SUBMISSION WAVERLEY COLLEGE ALTERATIONS AND ADDITIONS PROPOSAL

SSD-42425537

A East-West Proposed 1:1000

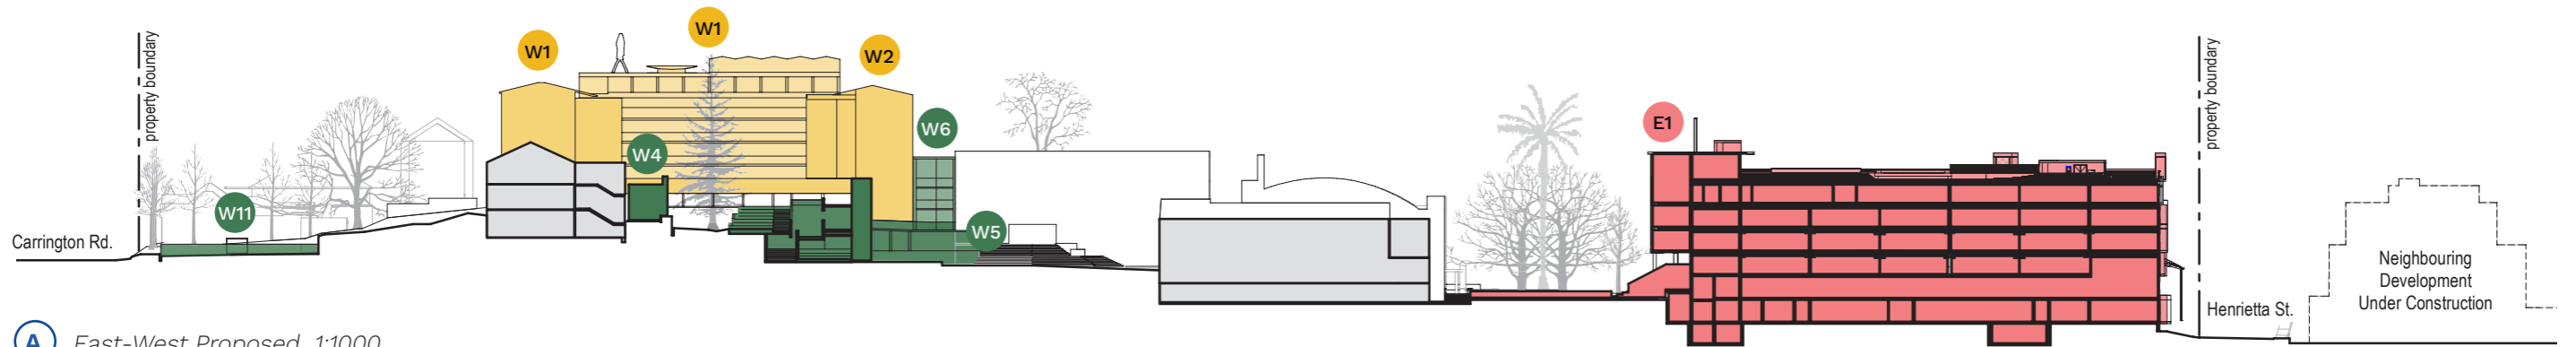
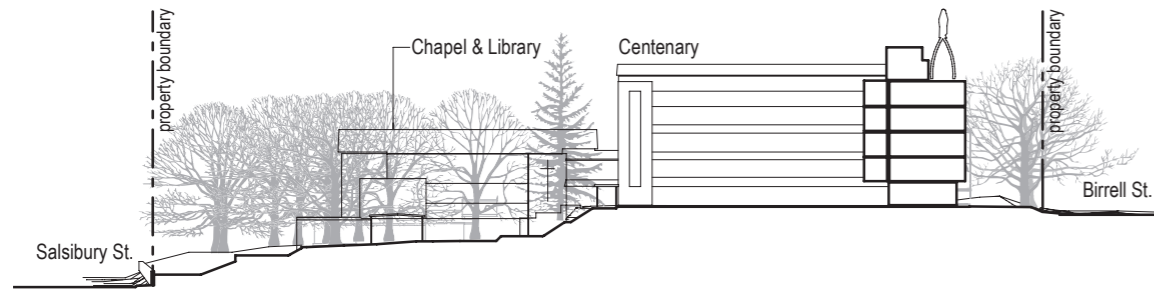
adjacent to Henrietta Street, and not central to Waverley College as stated in Table 1 of the same document, so shadowing of adjacent development (e.g. The Langlee apartments) will be significant.

The following site west-east section from “SEARs Request Scope Plans” shows how close the proposed 6 story building comes to the property boundary, and to the Langlee Apartments on the other side of the narrow Henrietta Street (see following figure).

**Image 3: Directional Distribution of Winds Approaching Sydney International Airport**  
Recorded from 2000-2021

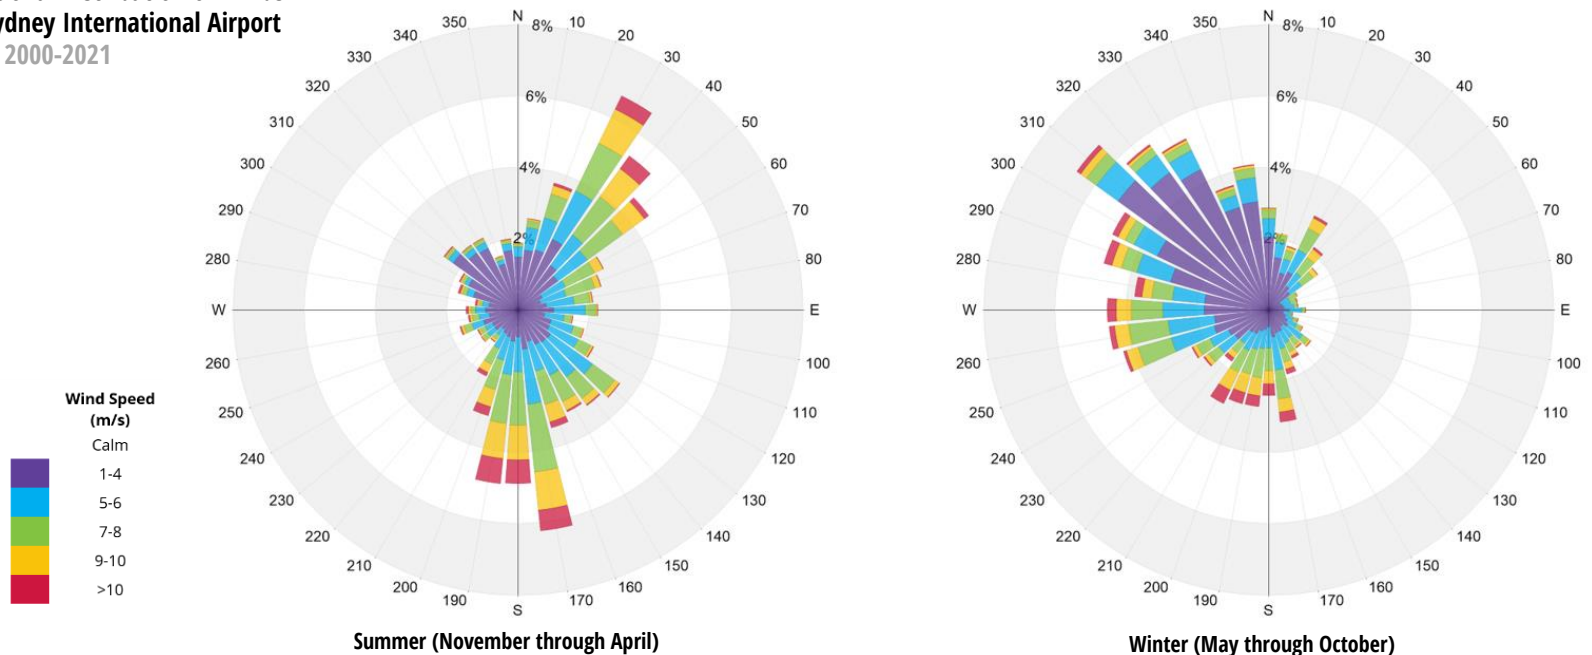
This report relies on summer and winter wind roses from the Sydney Airport. The low frequency of strong southerly winds in winter does not agree with our experience living in the Langlee Apartments with a south-facing patio. The southerly winds this last winter and spring have been so strong that our patio has frequently been unusable.

Image 5: General Wind Flow around Buildings with Examples of Common Wind Measures

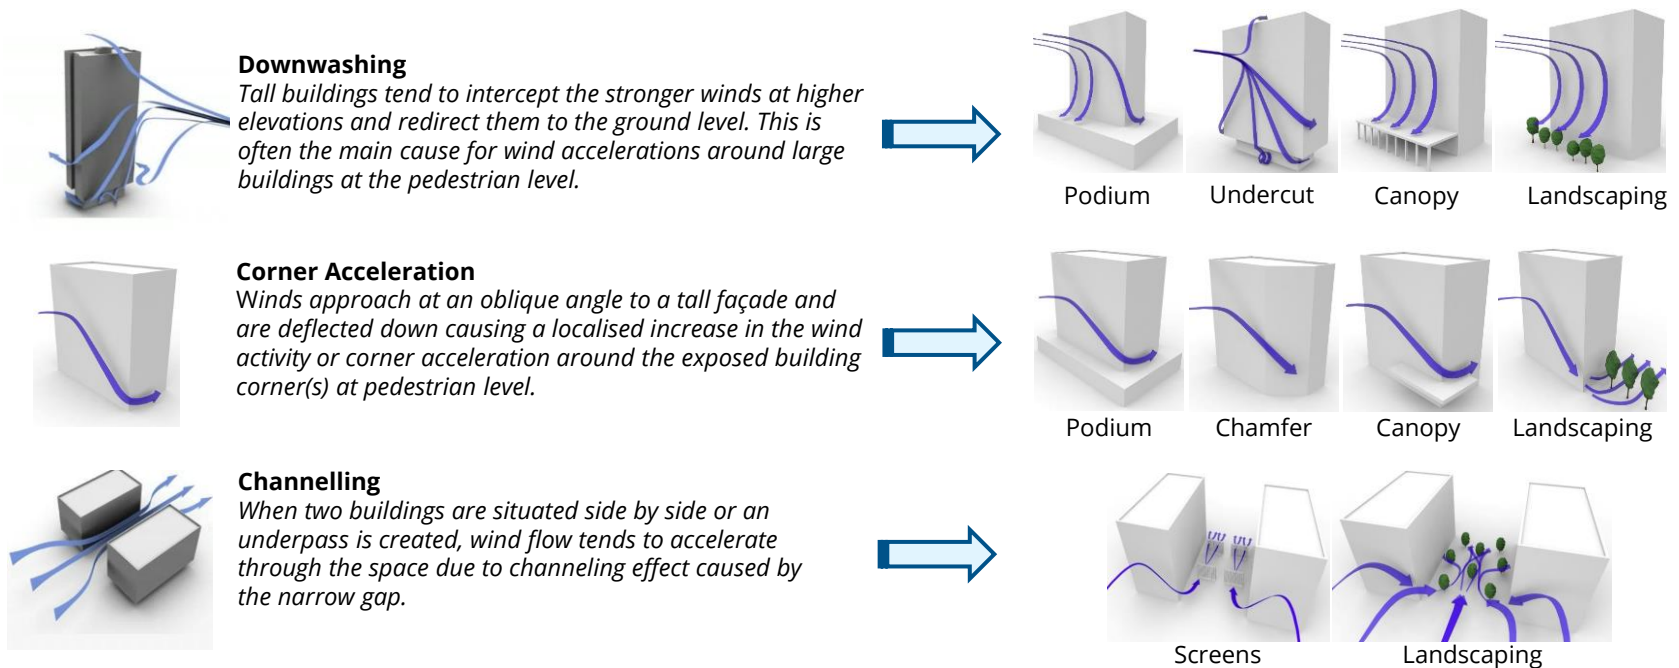
Image 5 in Appendix Y refers to the channelling that occurs when two buildings are situated side by side; wind flow tends to accelerate through the space due to the channelling effect caused by the narrow gap. The placement of the proposed six story building close to the narrow Henrietta Street boundary and close to the six story Langlee Apartments on the other side of Henrietta Street has the potential to cause channelling of wind resulting in dangerous conditions for pedestrians and cyclists during strong southerly winds. This will become worse with completion of stage 2 of the six-story building close to Henrietta Street.
